**From:** [Connor Armi](#)  
**To:** [Chace Pedersen](#)  
**Cc:** [Guy Moura](#); [Hanson, Sydney \(DAHP\)](#)  
**Subject:** Re: ACU-23-00004 ACX - Notice of Application  
**Date:** Tuesday, September 19, 2023 10:59:23 AM

This consult is in reference to Conditional Use Permits ACU-23-00004 ACX. Ground disturbing activities include the construction of a large building (12000 FT<sup>2</sup>) with additional buildings planned for construction. There are other buildings on the property and the limited "narrative" did not provide a detailed work plan for the scope of the project.

SITE PLAN

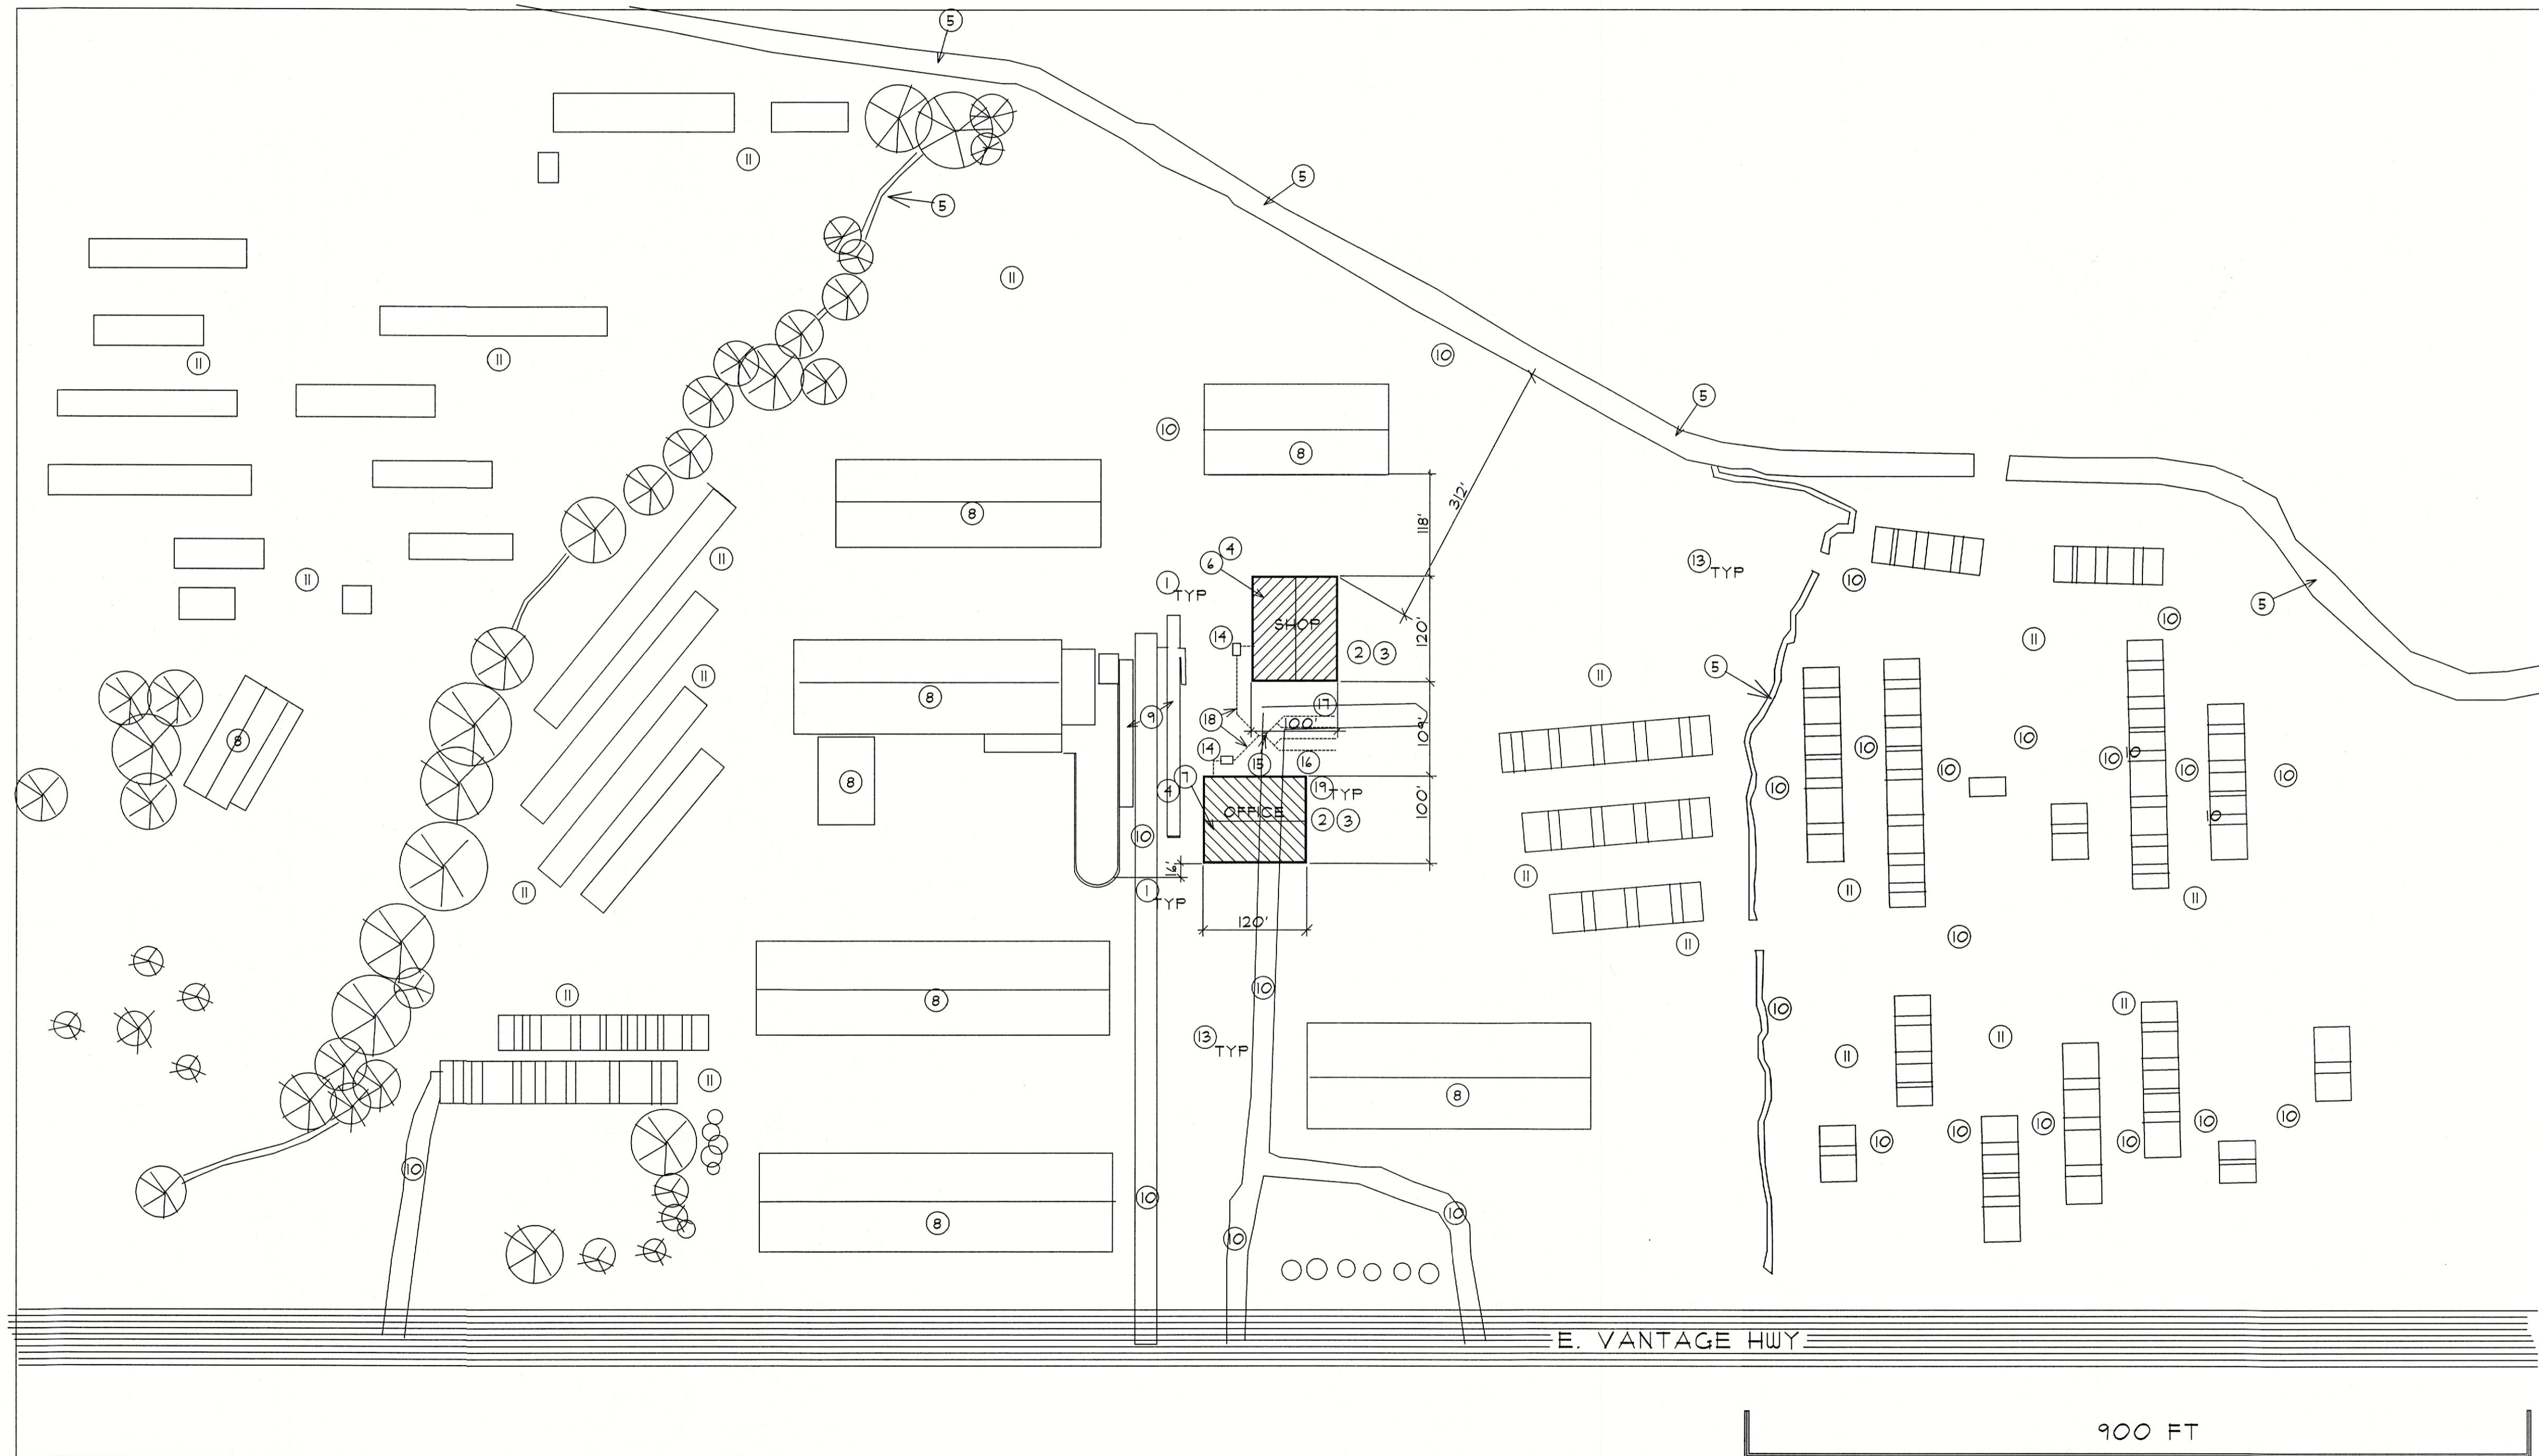
If ground disturbing activities are to be conducted, such as the building construction, installation of a septic system, or the scraping of a driveway, a cultural resource surface survey and sub-surface testing of the area in and directly around the proposed ground disturbance are recommended as a surface observation will not be an accurate assessment of the existent potential for subsurface cultural deposits. This test should be to the terminal depth of the septic installation to ensure the totality of the presence or absence of cultural material.

Due to the previous development and the clearly impermeable surfaces nearby CCT requests a cultural resource survey prior to implementation and then a cultural resource monitor during to the implementation of ground disturbing activities and that during implementation that there be an inadvertent discovery plan or (IDP) in place to ensure compliance with all Section 106 and relevant cultural resource laws both federally and to the state of Washington.
